**WELWYN HATFIELD BOROUGH COUNCIL
EXECUTIVE DIRECTOR - PLANNING, PUBLIC PROTECTION AND GOVERNANCE**

Application No: 6/2019/2571/VAR
Location: 101 Brookmans Avenue, Brookmans Park, Hatfield, AL9 7QG
Proposal: Variation of condition 11 (approved drawings) on planning permission 6/2019/0434/FULL
Officer: Mr David Elmore
Recommendation: Granted

6/2019/2571/VAR

Drawing Title
 HOUSE 3

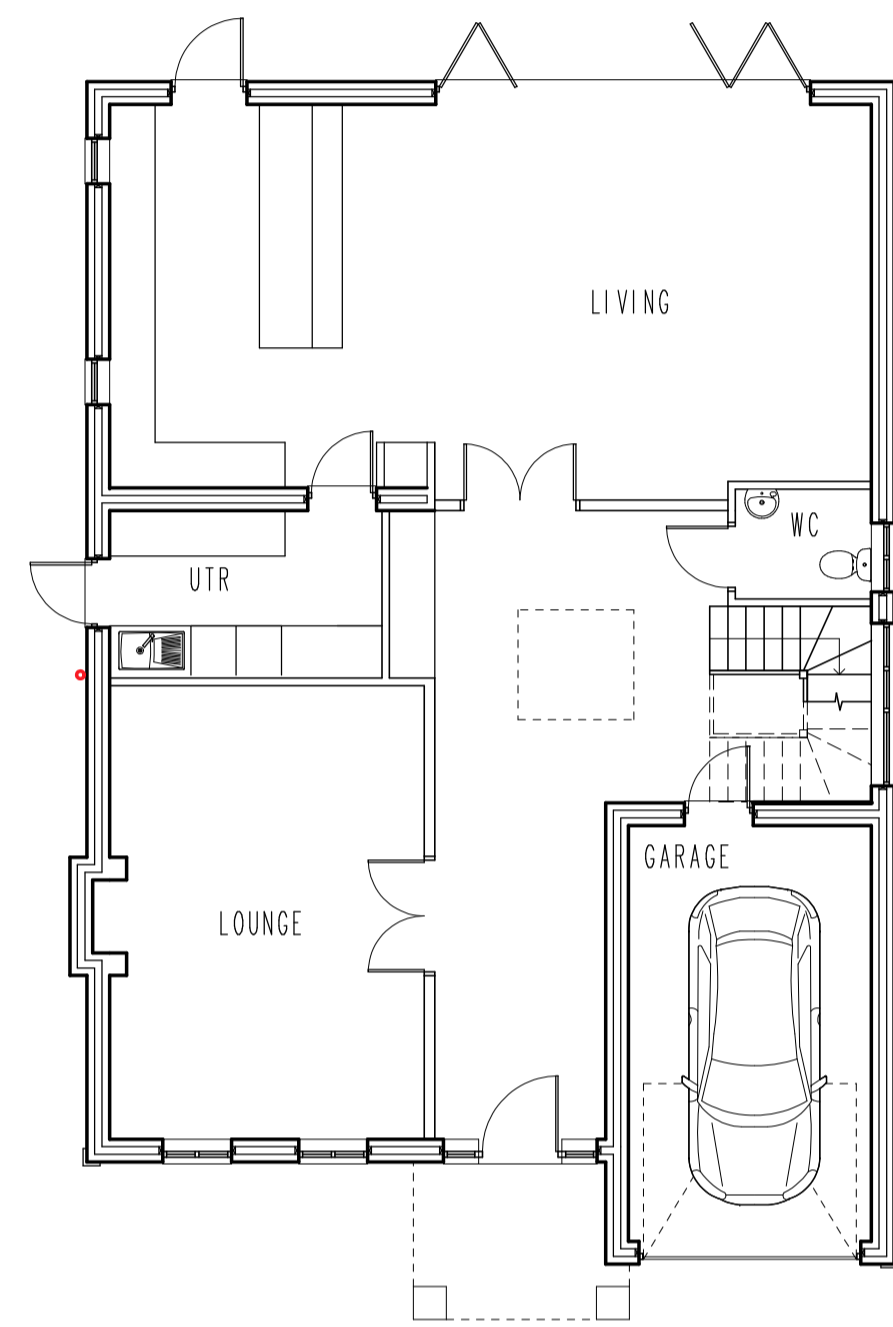
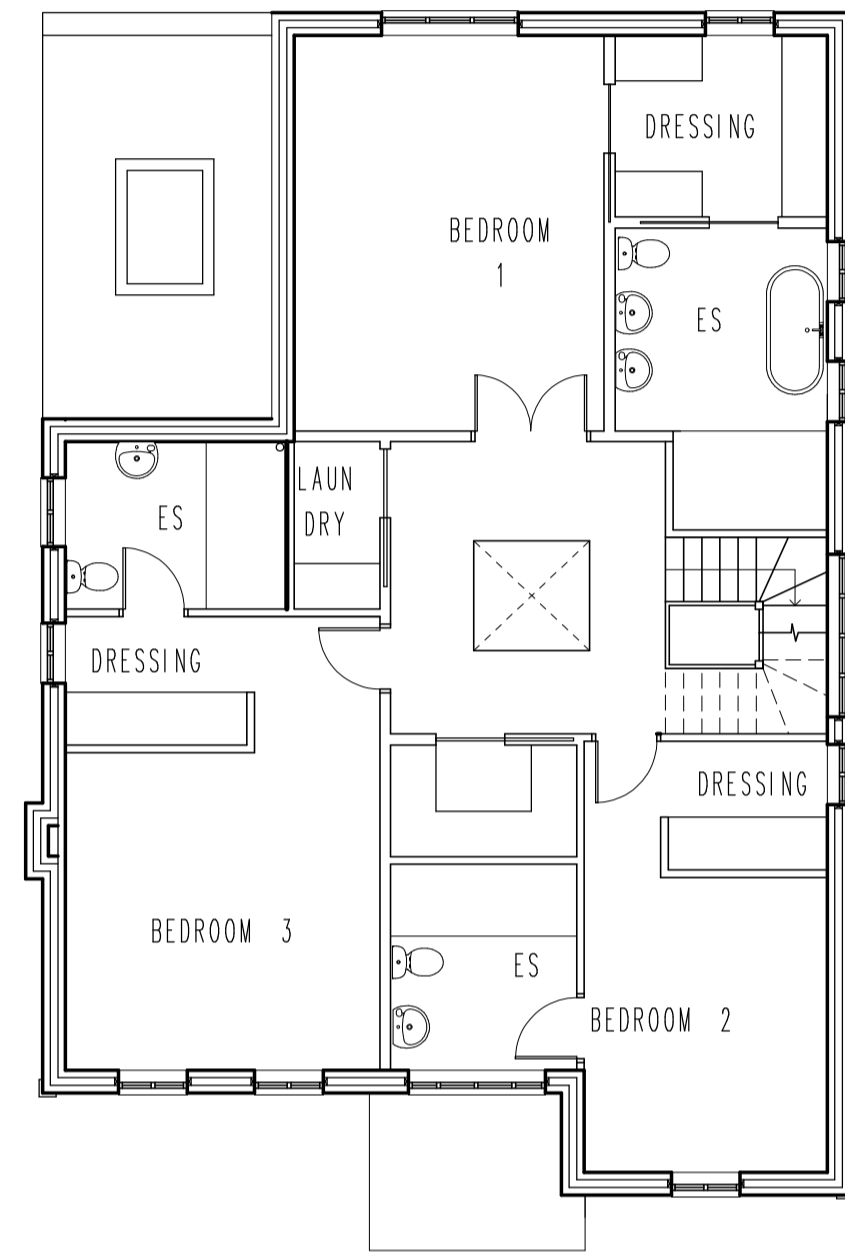
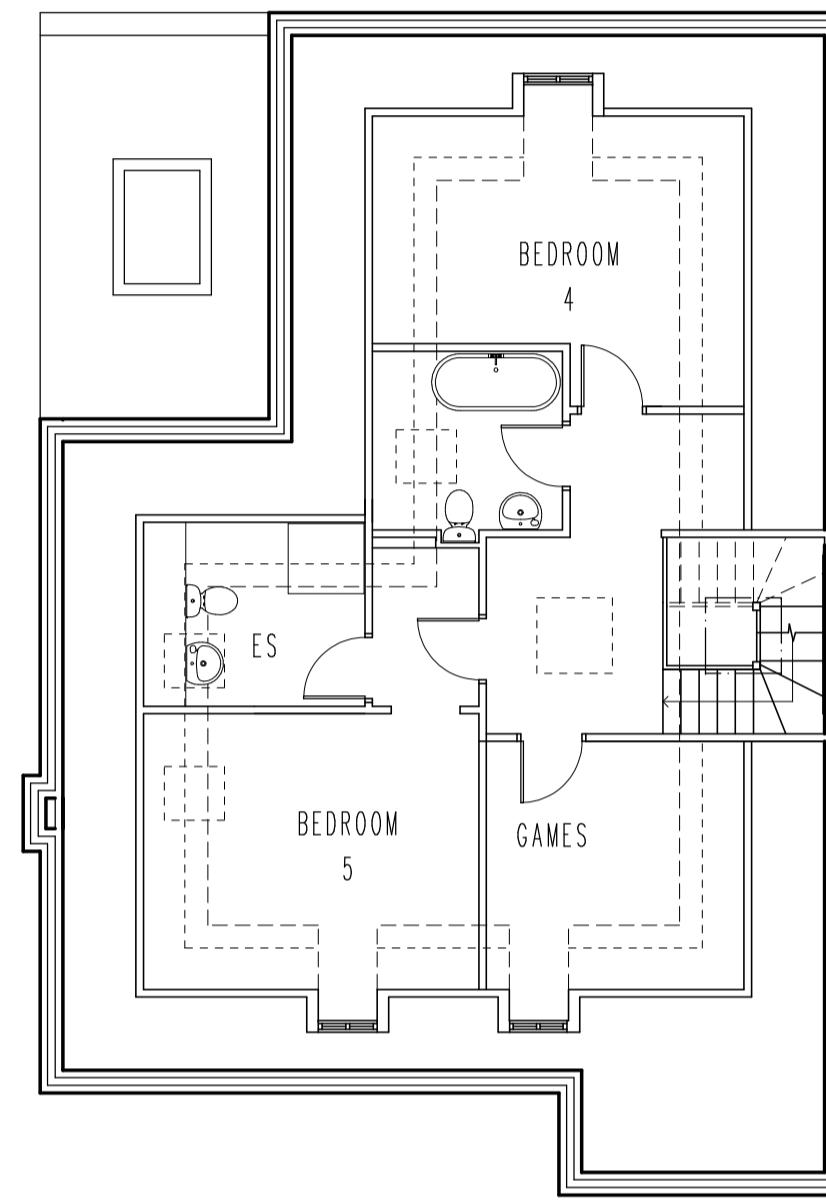
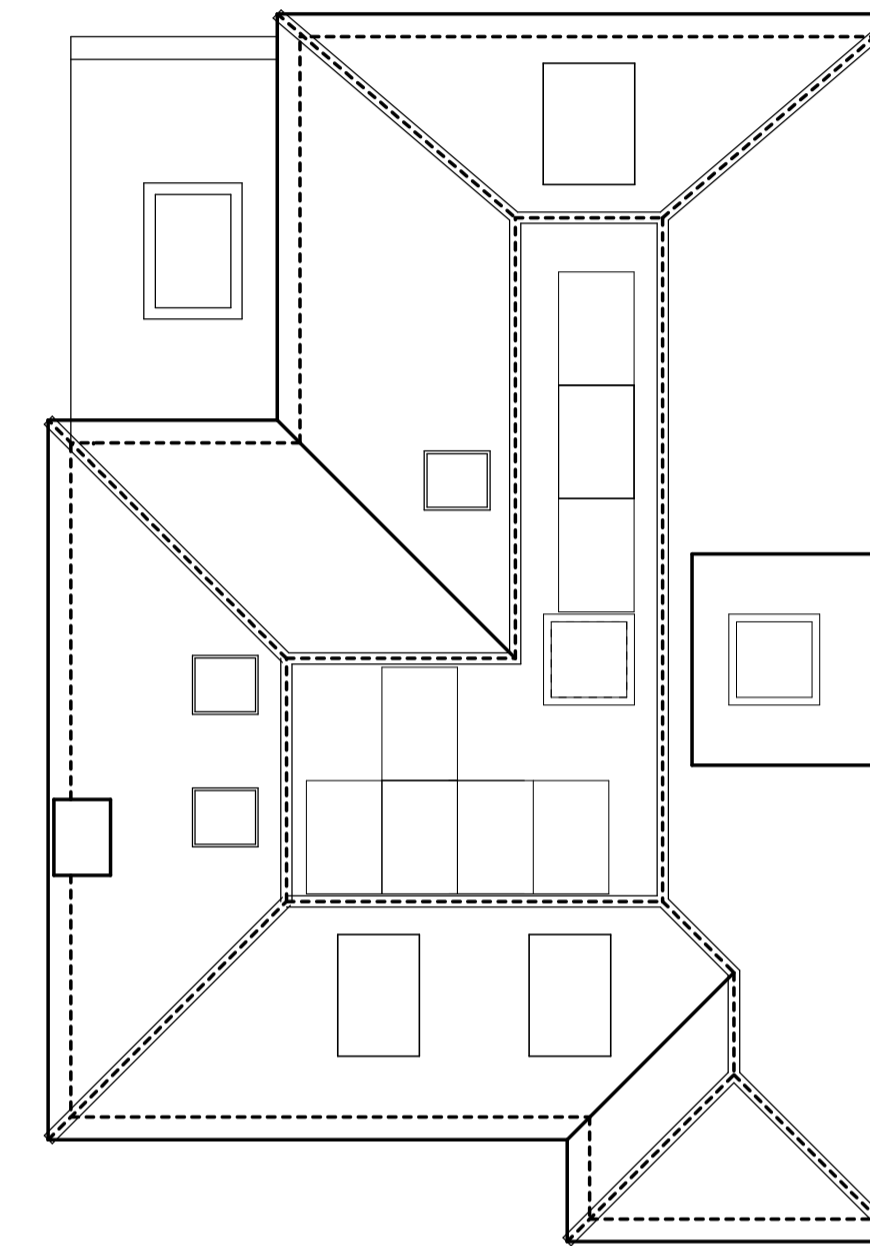
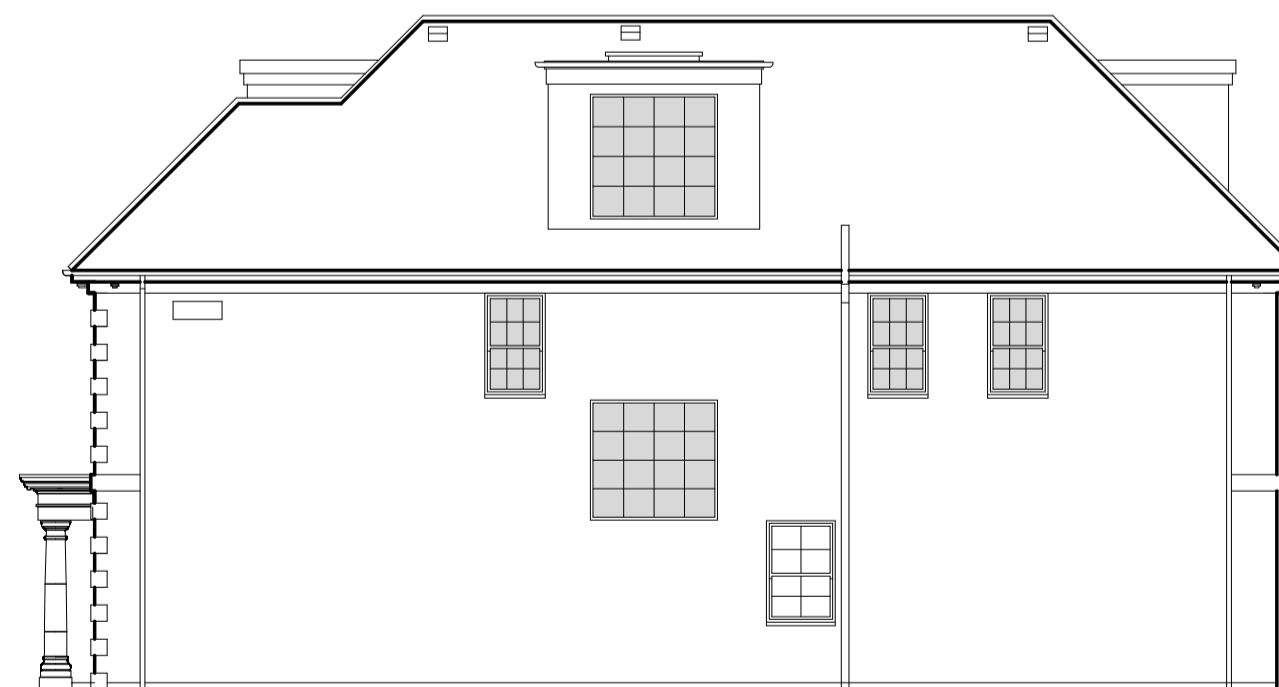
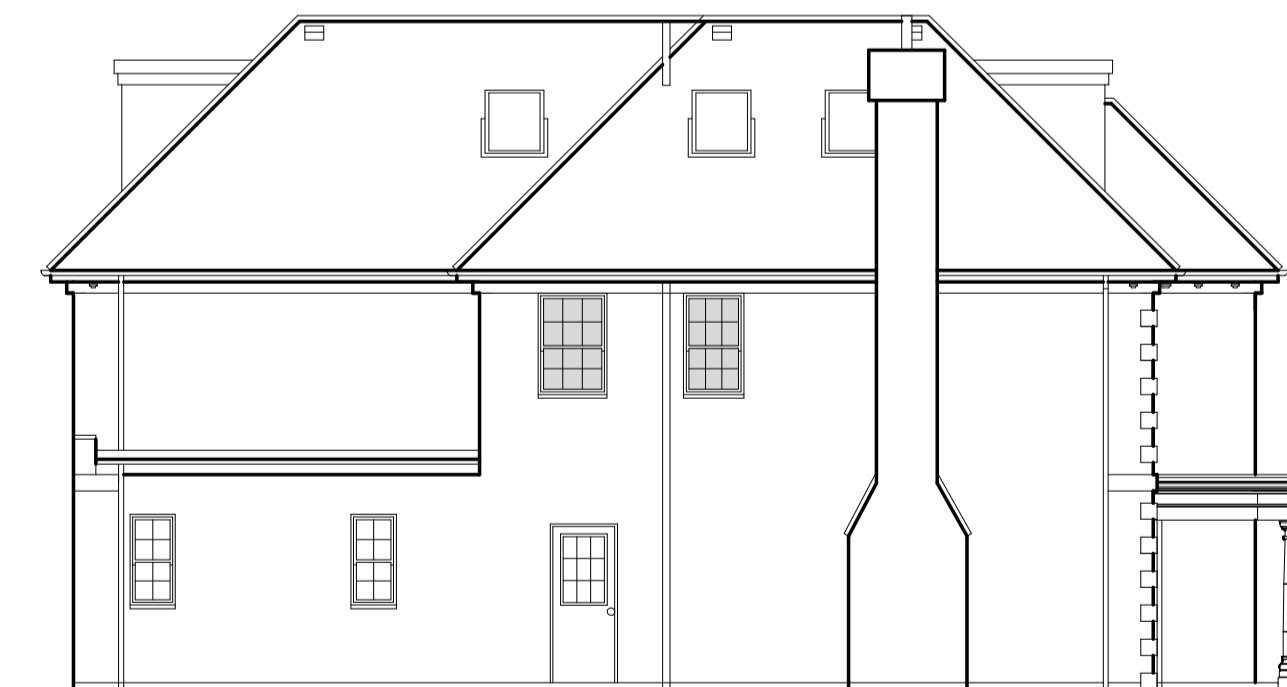
Context	
Site and Application description	<p>This application seeks a variation to condition 11 (approved plans) of planning permission: 6/2019/0434/FULL. The proposed changes to the approved plans include:</p> <ul style="list-style-type: none"> - Increase in size of side dormer serving staircase of Houses 3, 4 & 5. Width increased by 0.6 metres; - One parking space removed from front driveway of Houses 3, 4 & 5; - Study of Houses 3, 4 & 5 replaced with a garage; and - Fenestrations details of Houses 3, 4 & 5 amended
Constraints (as defined within WHDP 2005)	<p>PAR - PARISH (NORTH MYMMS) Wards - Brookmans Park & Little Heath</p>
Relevant planning history	<p>Application Number: 6/2019/3006/COND Decision: Under consideration Decision Date: Proposal: Submission of details pursuant to condition 2 (crown roof details) and condition 3 (biodiversity and external lighting) on planning permission 6/2019/0434/FULL</p> <p>Application Number: 6/2019/2313/FULL Decision: Under consideration Decision Date: Proposal: Erection of six dwellings following demolition of existing buildings</p> <p>Application Number: 6/2019/2155/COND Decision: Part Approved / Part Refused Decision Date: 24 October 2019 Proposal: Submission of details pursuant to condition 1 (Materials), 2 (Crown Roof) and 3 (Biodiversity and Lighting) on planning permission 6/2019/0434/FULL</p> <p>Application Number: 6/2019/0434/FULL Decision: Granted</p>

<p>Would the development provide / retain sufficient parking?</p> <p><input checked="" type="checkbox"/> Yes <input type="checkbox"/> No</p> <p>Comment: Whilst Houses 3, 4 & 5 would lose a parking space within the front driveway, each of these dwellings would now benefit with an integral garage to serve one car. As such, there would be no net loss of on-site parking provision.</p>
<p>Any other considerations</p> <p><i>Landscaping</i></p> <p>The extension of the driveways reduces a small amount of landscaping by the fronts of plot 3, 4 & 5 and boundary landscaping to Houses 1 & 2 is increased. Such changes are considered minor. An acceptable landscaping layout would remain.</p> <p><i>Re-imposition of remaining conditions subject to planning permission 6/2019/0434/FULL</i></p> <p>A successful application to amend condition 11 would result in the issue of what would be in effect a new planning permission, sitting alongside the original permission. To assist with clarity decision notices for the grant of planning permission under section 73 should also repeat the relevant conditions from the original planning permission, unless they have already been discharged.</p> <p>Condition 1 (external materials) of planning permission 6/2019/0434/FULL has been discharged under application 6/2019/2155/COND. The approved external materials would be listed in a varied condition if this section 73 application were to be approved.</p> <p>All other conditions of planning permission 6/2019/0434/FULL remain relevant and would be re-imposed if this section 73 application were to be approved.</p>
